Immingham Green Energy Terminal

TR030008

8.6 Applicant's Schedule of Changes to draft Development Consent Order

Applicant's Schedule of Changes to the draft Development Consent Order

Site Boundary & Works Plans Changes between DCO Application (September 2023) & Change Application (March 2024) Key Plan

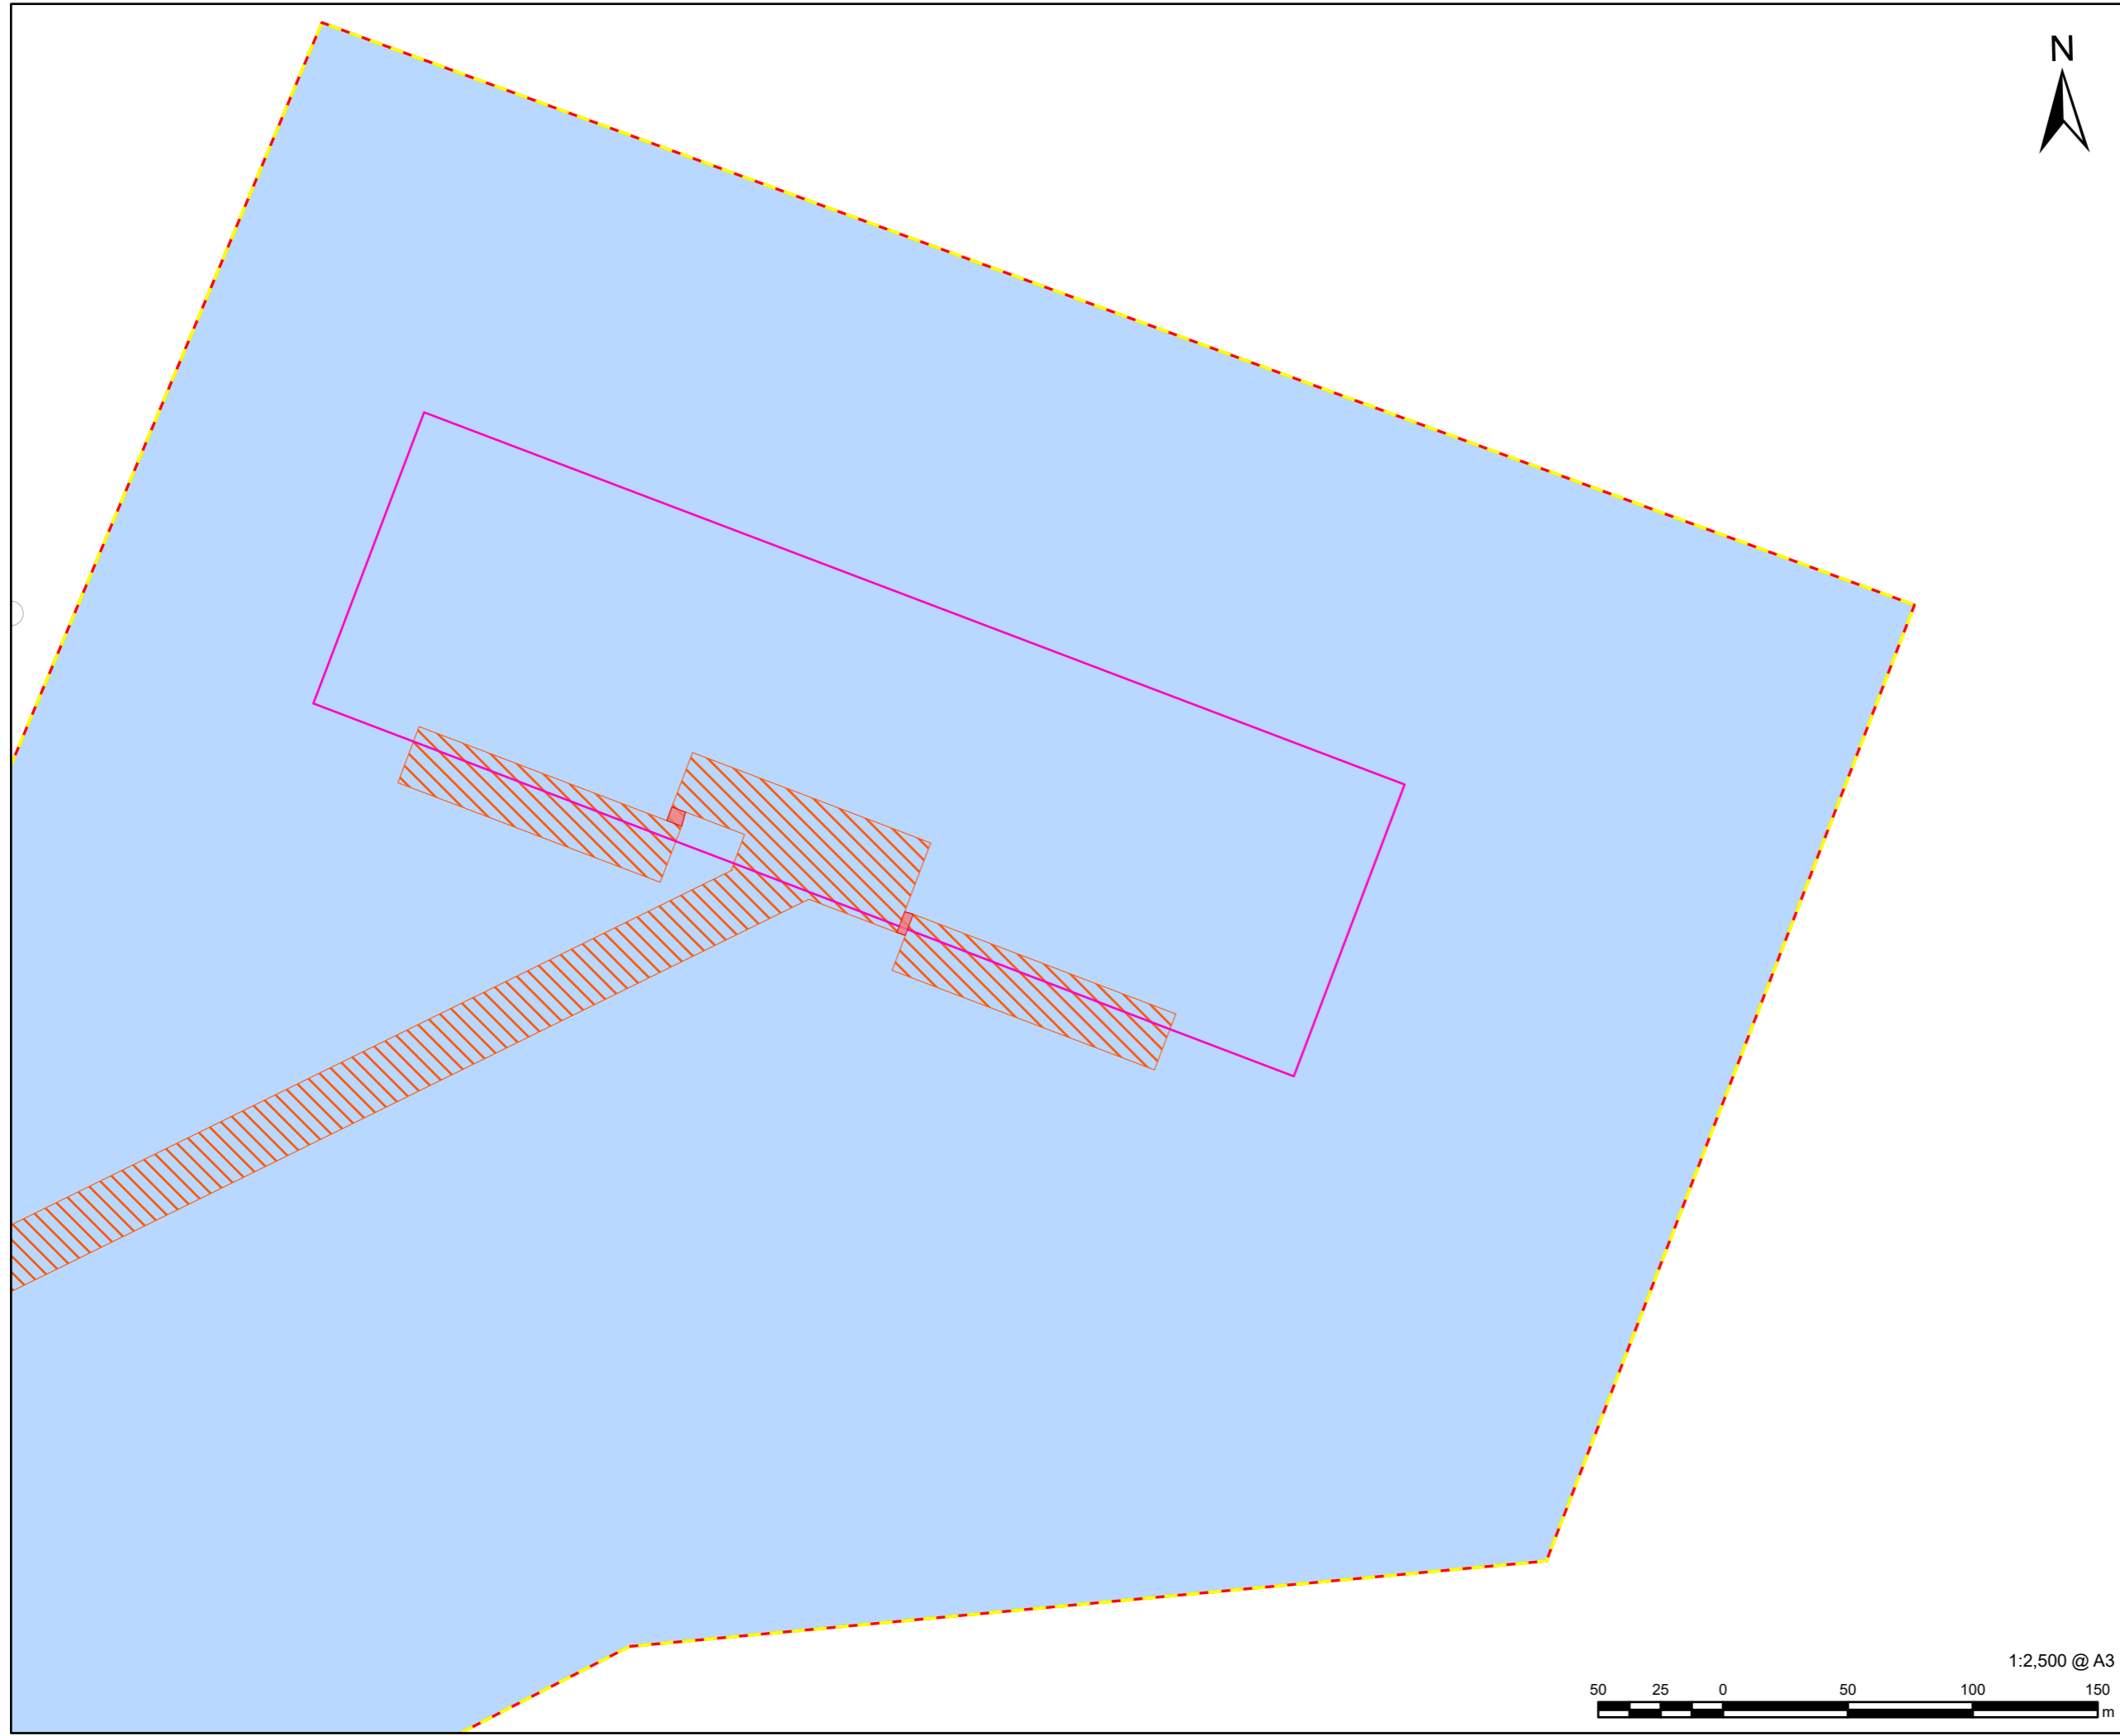
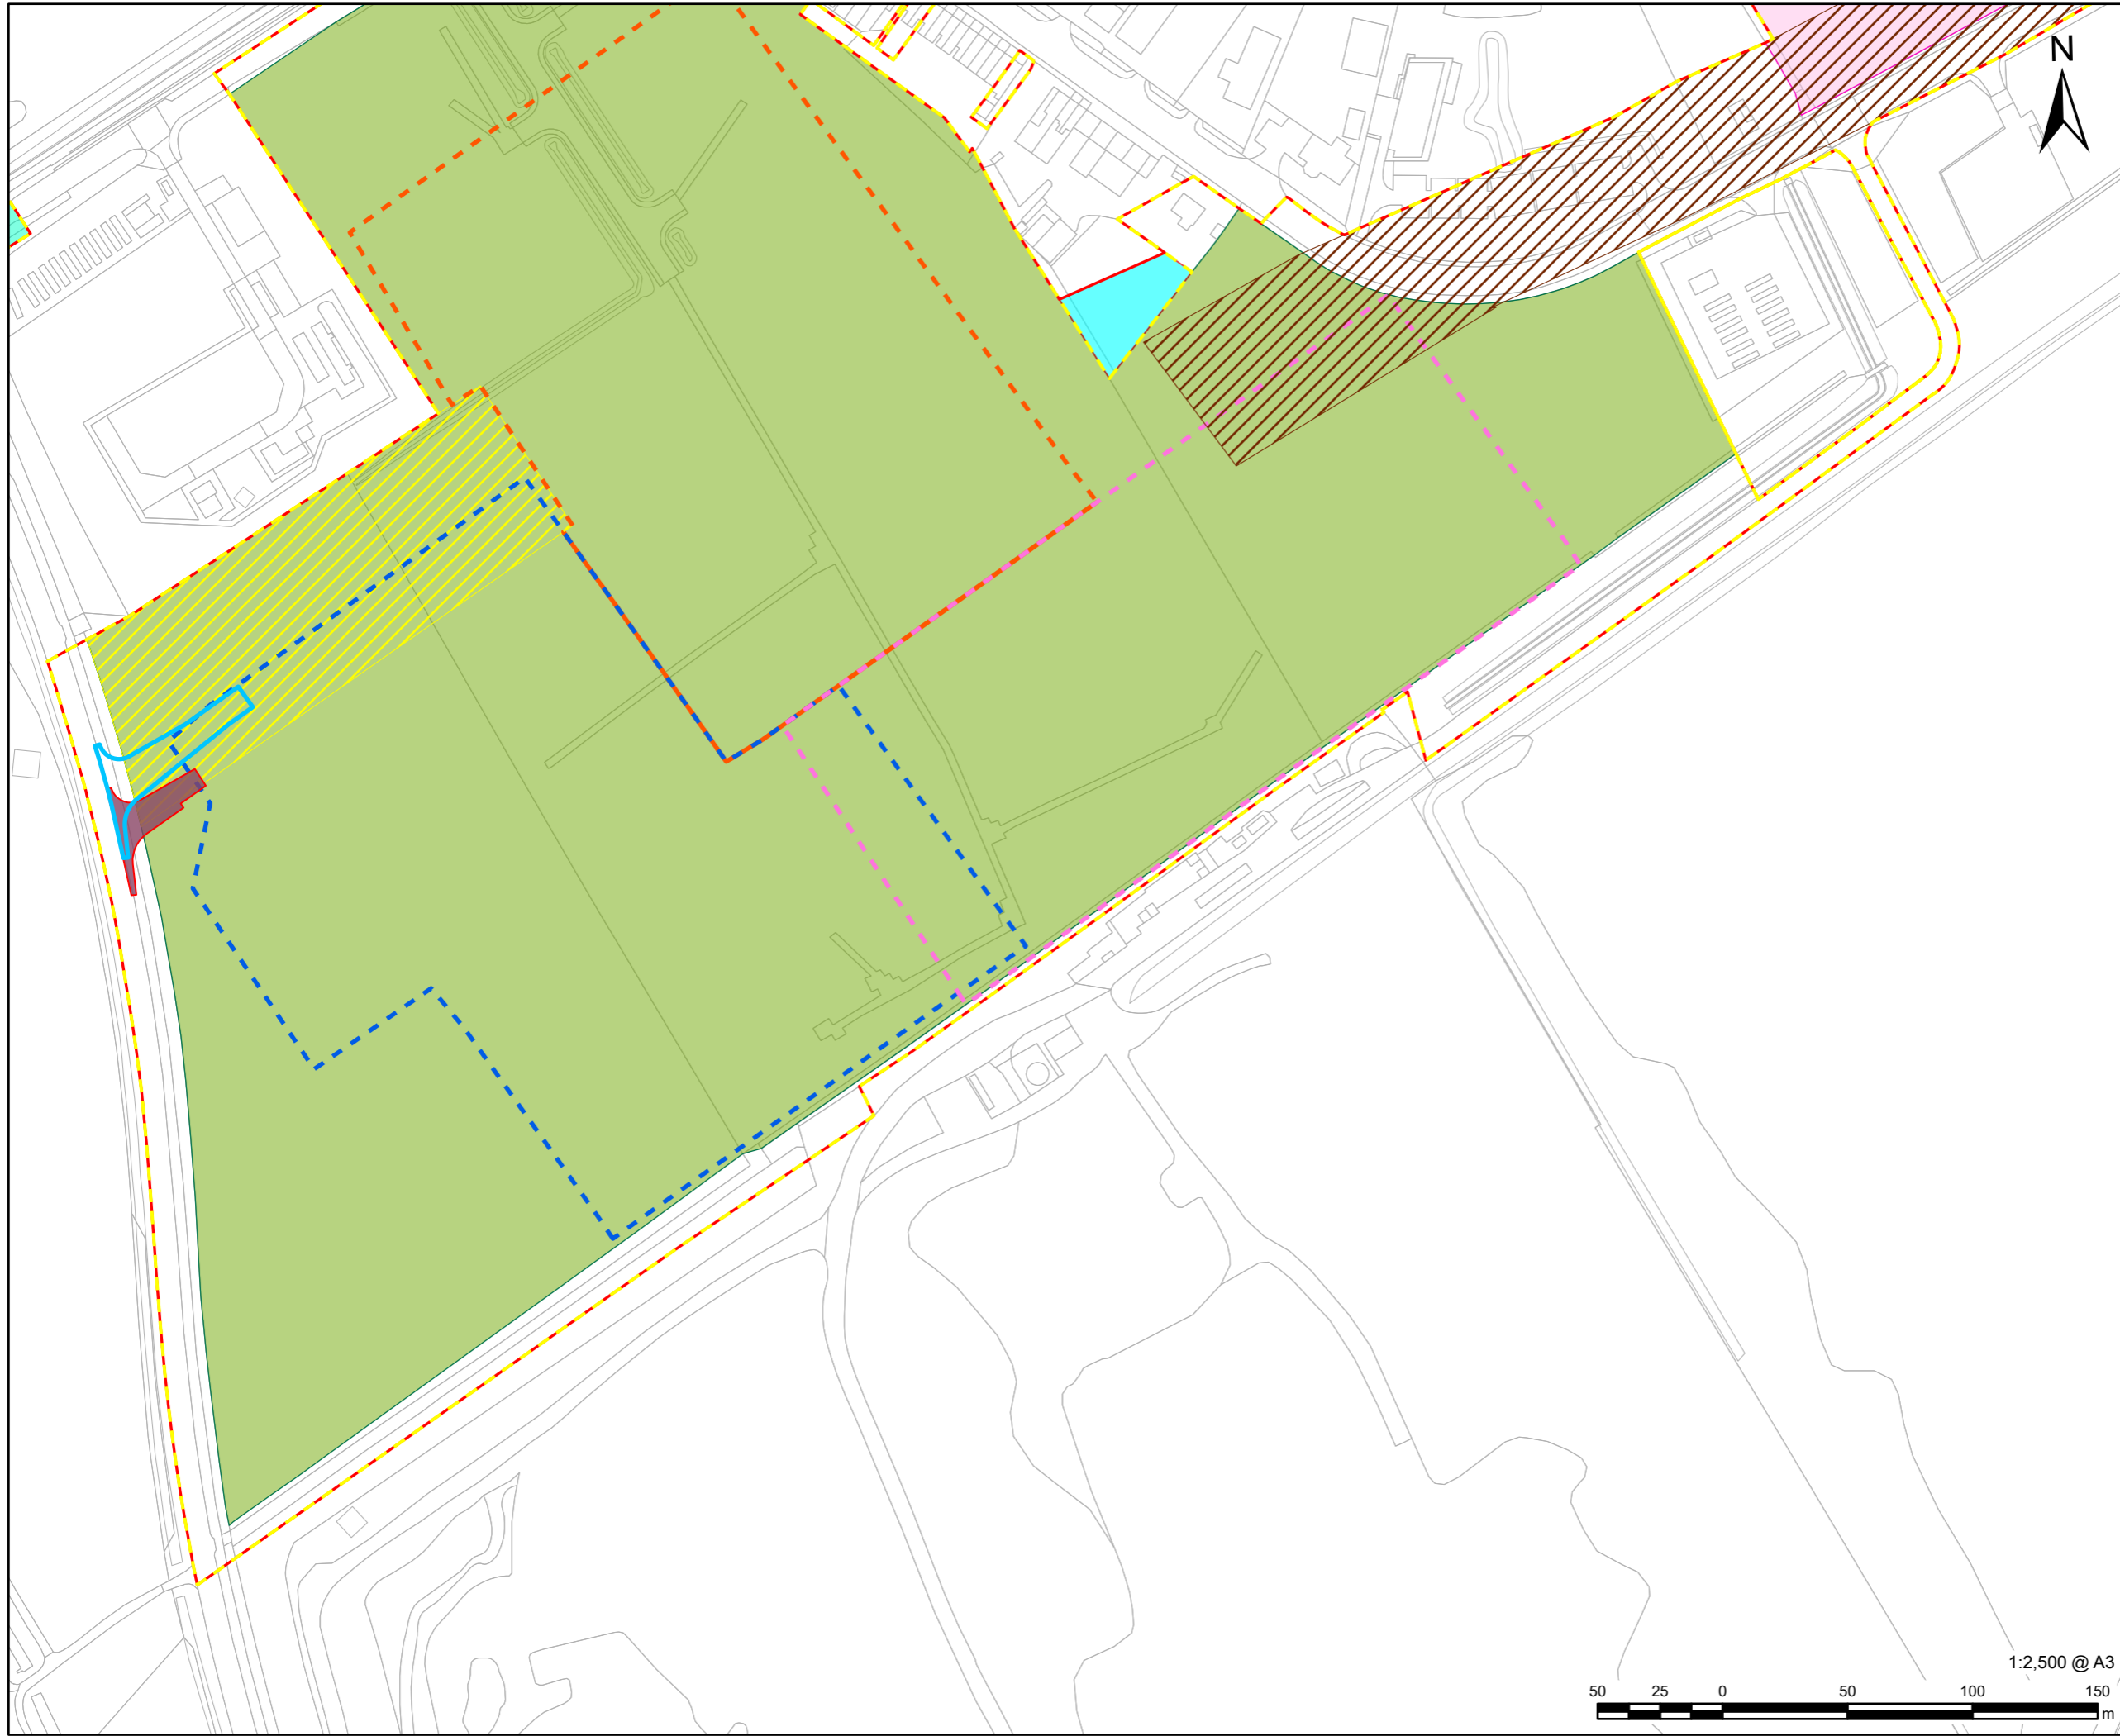
Ref.	dDCO Ref.	Rationale for Change	Change Made	Version of dDCO
4.	Article 6, Extent of Certain Works	The amendments have been made in order to provide further clarification regarding the location of the dredged pocket, now shown indicatively in the Works Plans (document reference AS/002), further to the request of the Examining Authority at Box 30 of the S55 Checklist and first referenced in the applicant's letter of 3 January 2024 to Mr Karl-Jonas Johansson of the Planning Inspectorate.	<p>6. —(1) is <u>Subject to paragraph (2) , in</u> carrying out the authorised project comprising the works numbered in Part 1 (authorised development) in Schedule 1 (authorised project) the undertaker must, where the works plans set out the lateral extent of the area in which the numbered work comprised in the authorised project is to be located, carry out, maintain, use or decommission the numbered work within the lateral extent of the area set out for it on those plans.</p> <p><u>(2) For the purposes of paragraph (1), the lateral extent of the area for the dredged pocket described in paragraph 1(b) of Part 1 (authorised development) of Schedule 1 (authorised project) is not to be taken as the area set out on the works plans, which is shown on those plans for indicative purposes only, and the area within which the dredged pocket described in paragraph 1(b) of Part 1 (authorised development) of Schedule 1 (authorised project) must be carried out is instead to be taken from time to time to be the area bounded by the grid coordinates specified in paragraph 5(2) of the deemed marine licence or such other area for the dredged pocket as is specified in any marine licence granted or varied pursuant to the 2009 Act (including any variation of the deemed marine licence).</u></p>	Revision 2
